re:	Geotechnical Response to City Comments Proposed Python Complex - 222 Citigate Drive (Block 13) - Ottawa
to:	Broccolini Construction - Mr. Russell Beach - russell.beach@broccolini.com
to:	Broccolini Construction - Mr. James Lucas - jamesl@broccolini.com
date:	June 2, 2020
file:	PG5284-MEMO.03

# **Grading Plan - Comment 22**

# Grading Plan - Comment 23

PYTHON LP.
PROPOSED DEVELOPMENT - PROPOSED RETAINING WALL
HIGHWAY 416 AT FALLOWFIELD ROAD
OTTAWA, ONTARIO
Title: **STONE STRONG RETAINING WALL DESIGN - WALL SS1 AND SS2**

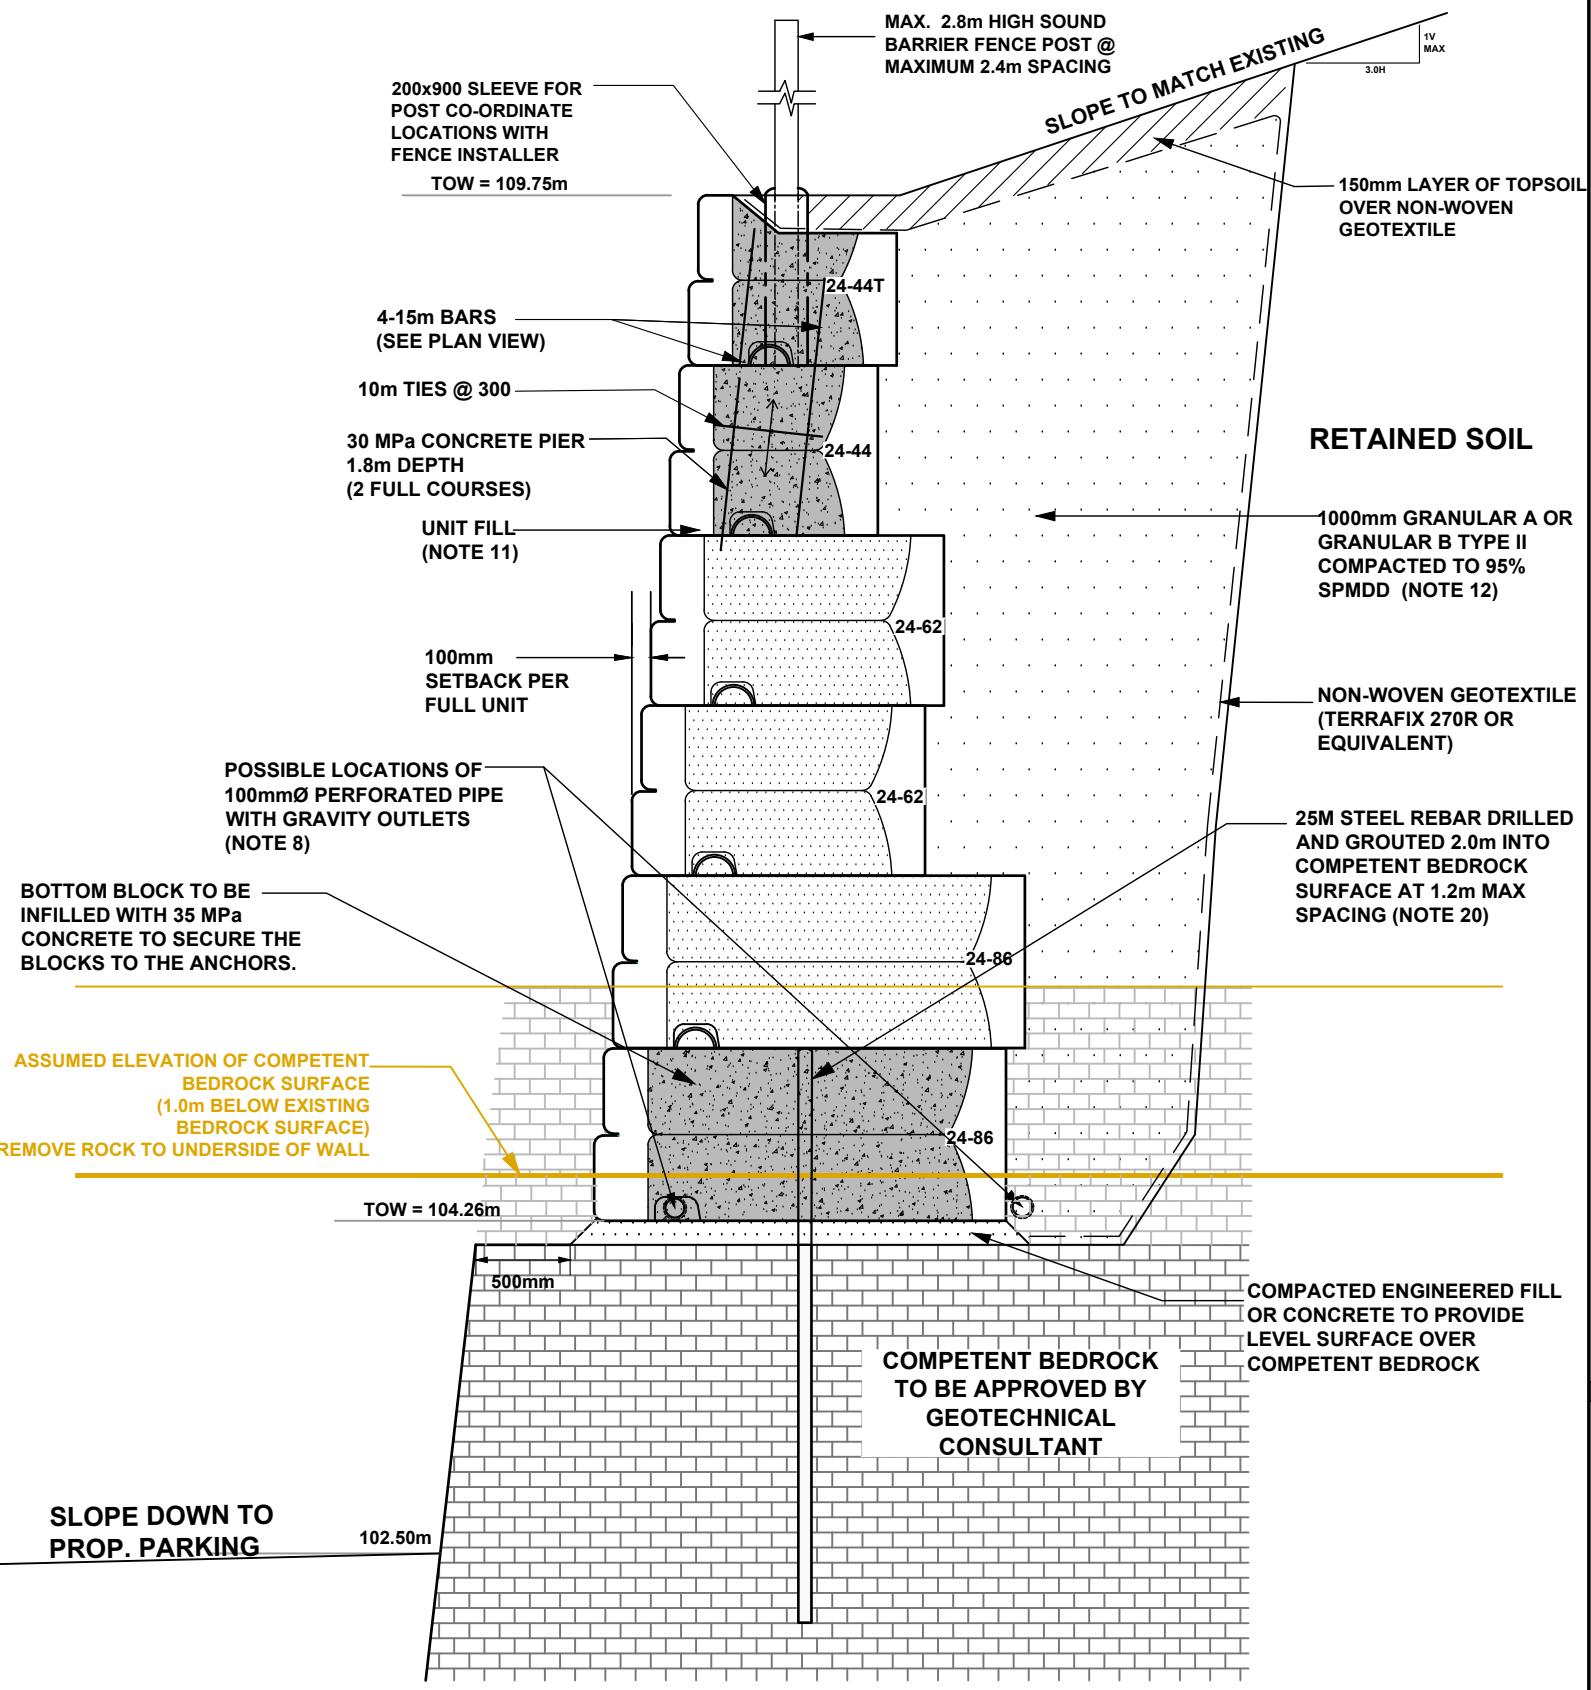
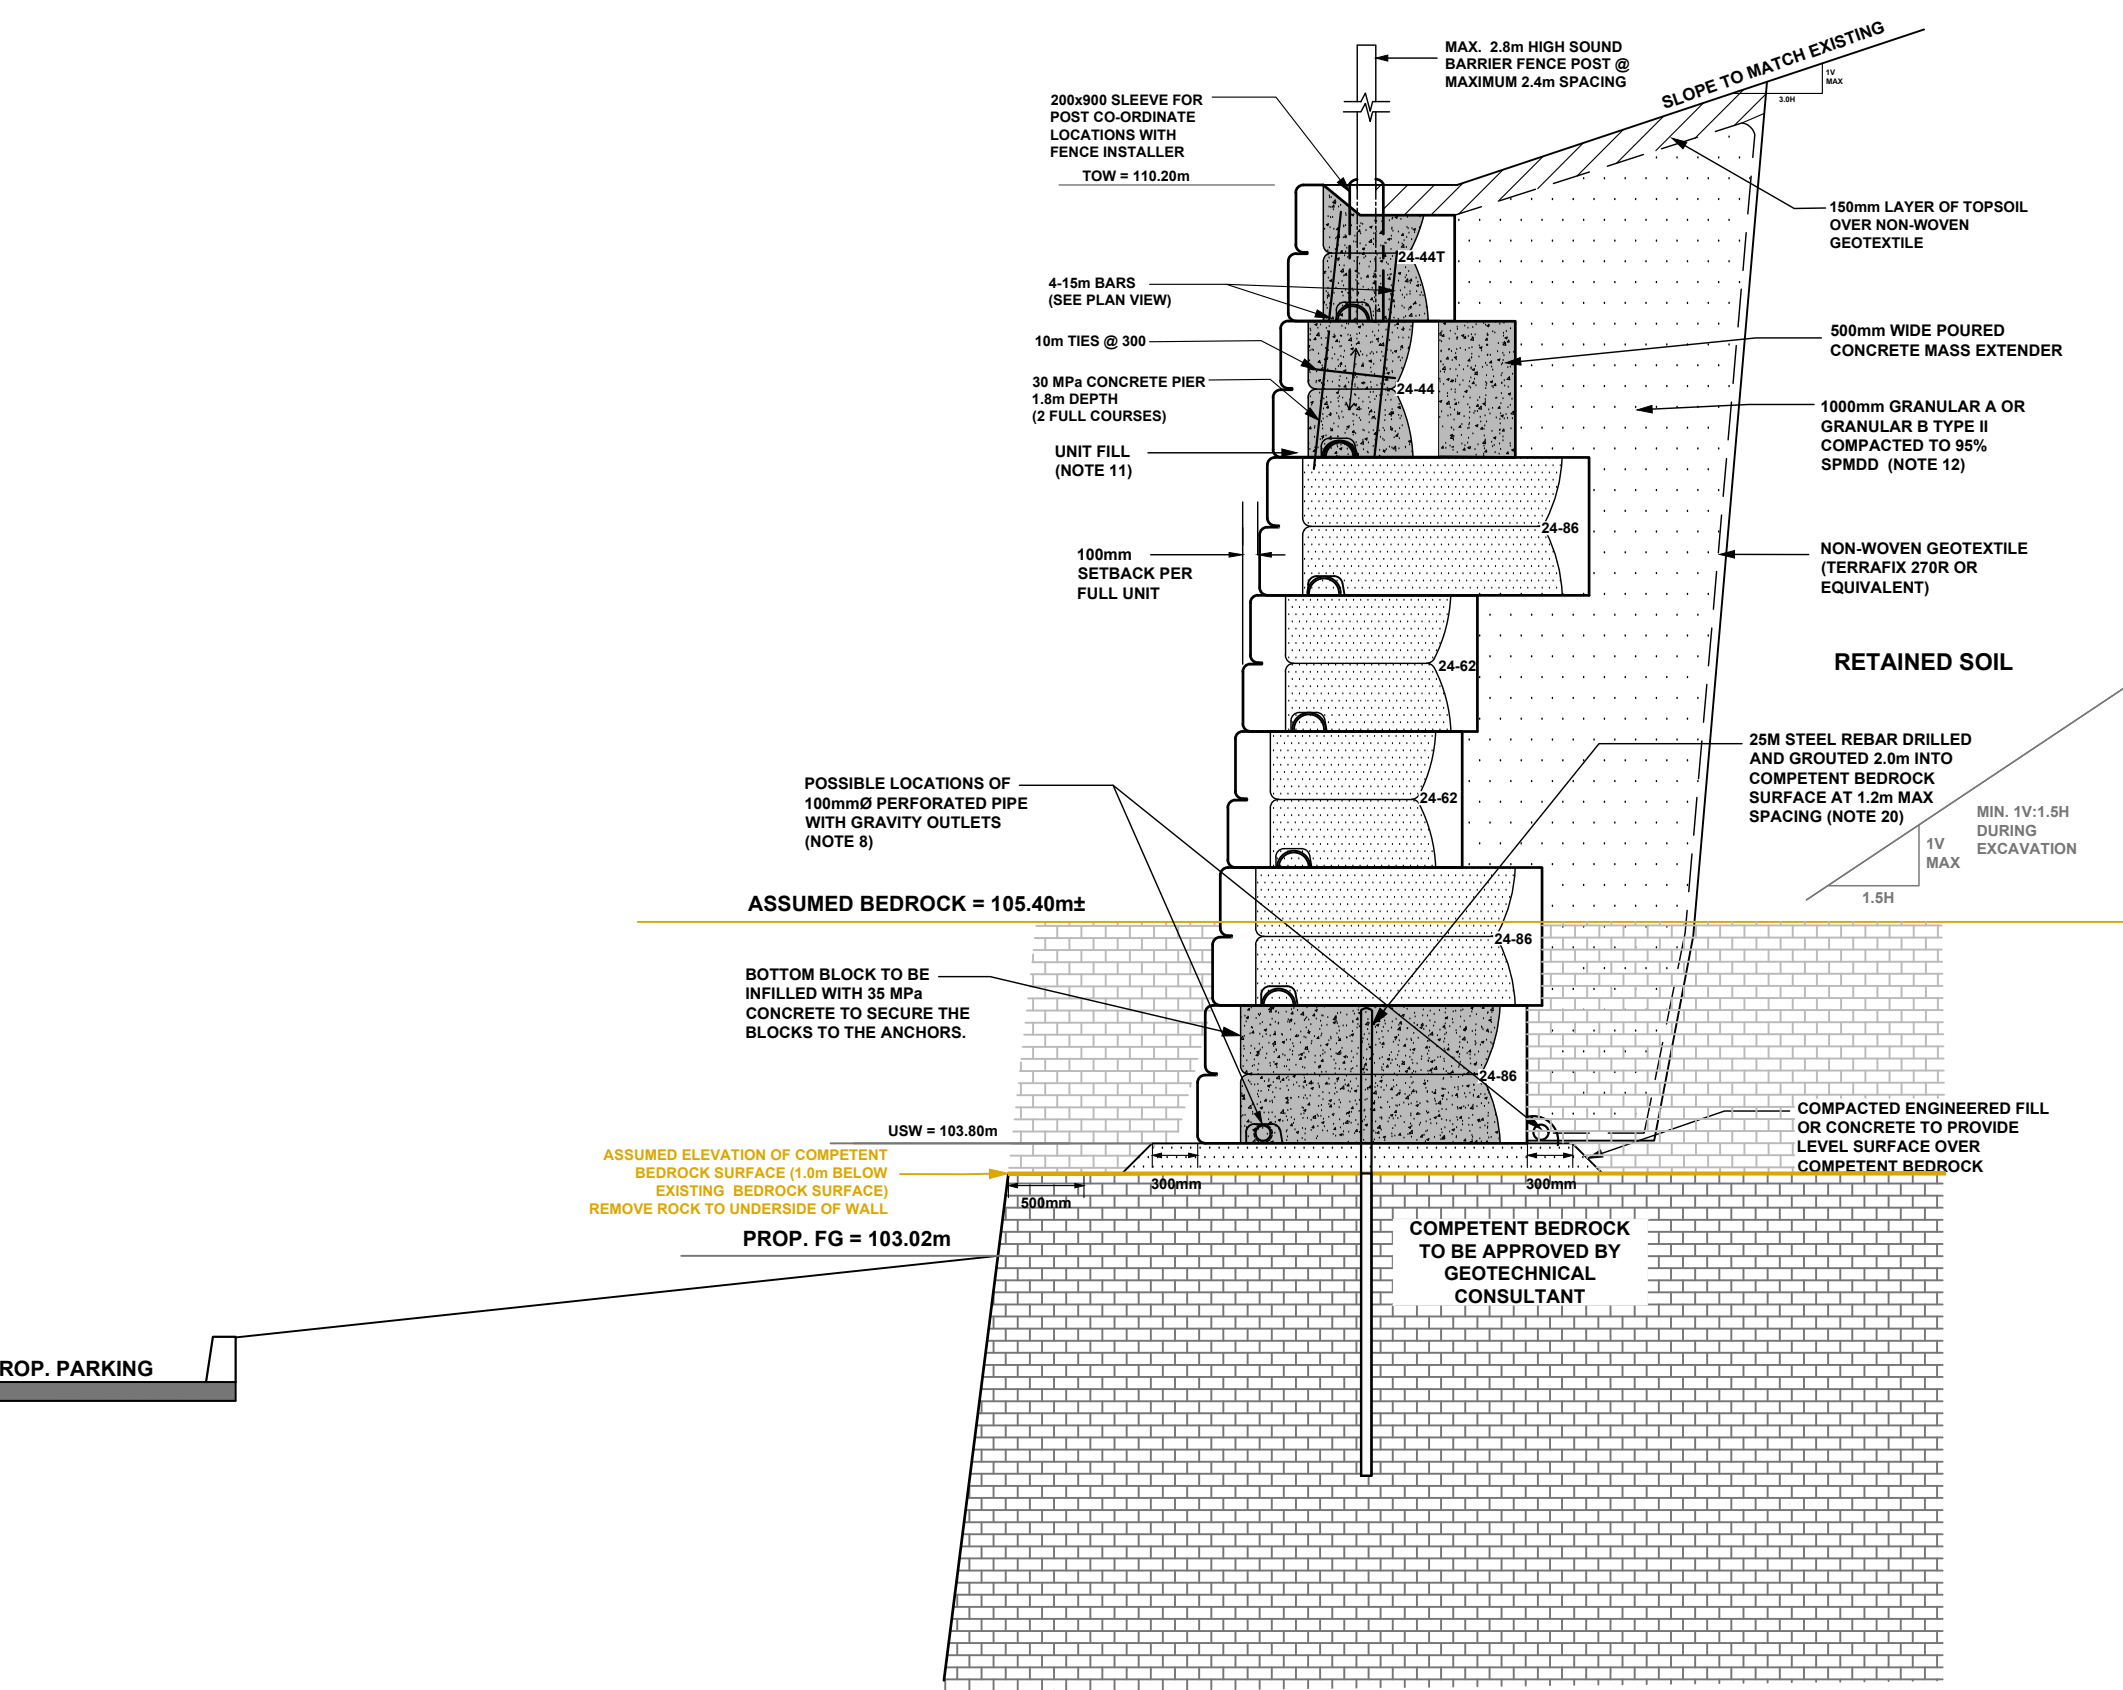
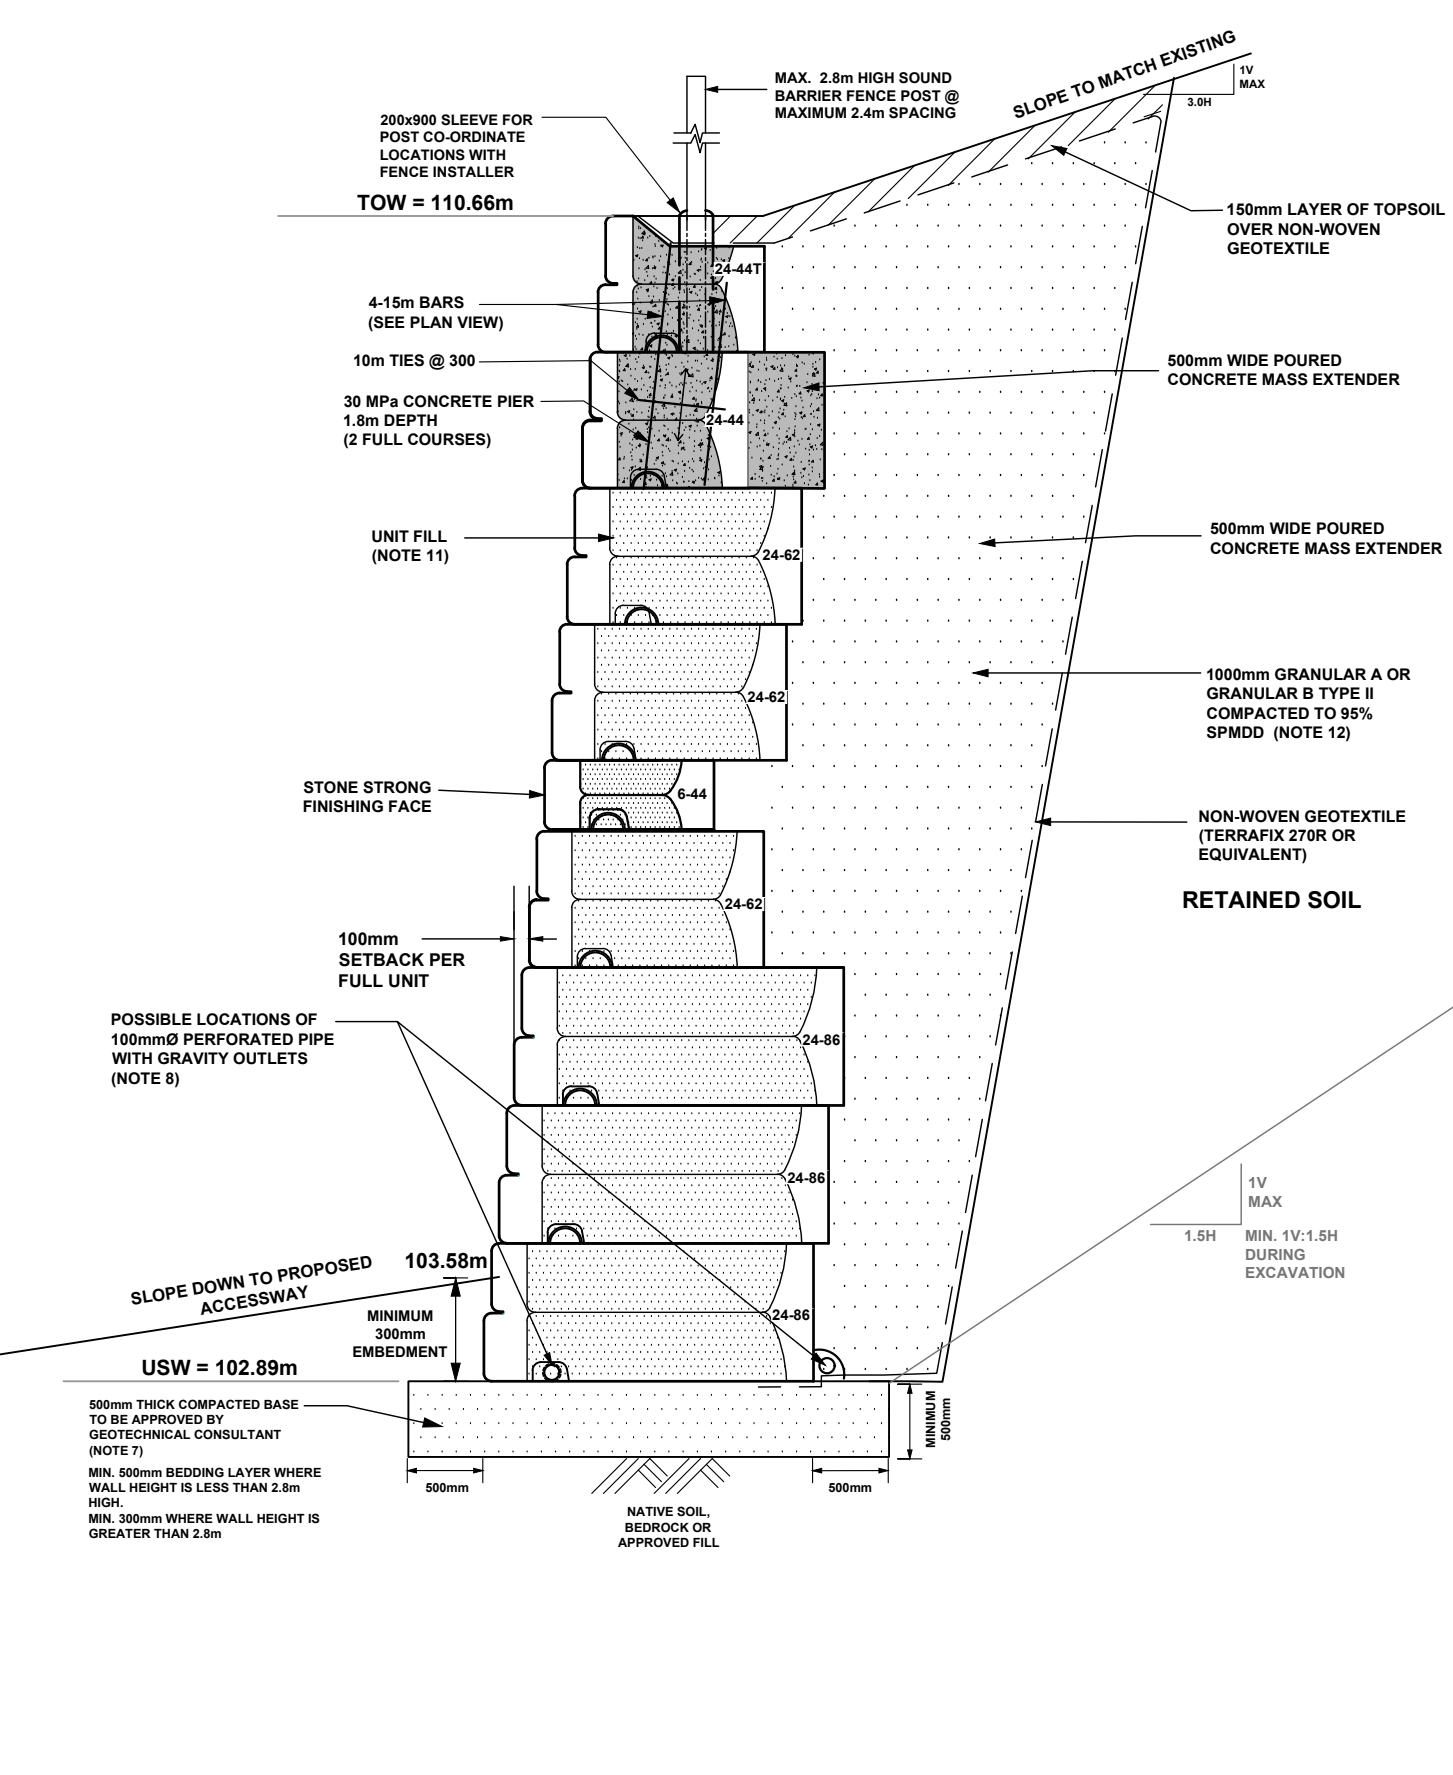
Please include details for the proposed retaining wall. Structural design is required for retaining wall greater than 1.0 in height.

Please refer to Drawing PG5284-2 Stone Strong Retaining Wall Profile - SS1 and SS2 and Drawing PG5284-3 Stone Strong Retaining Wall Design - Wall SS1 and SS2, Revision 1 dated May 14, 2020 enclosed for the design of the proposed retaining walls for the subject site.
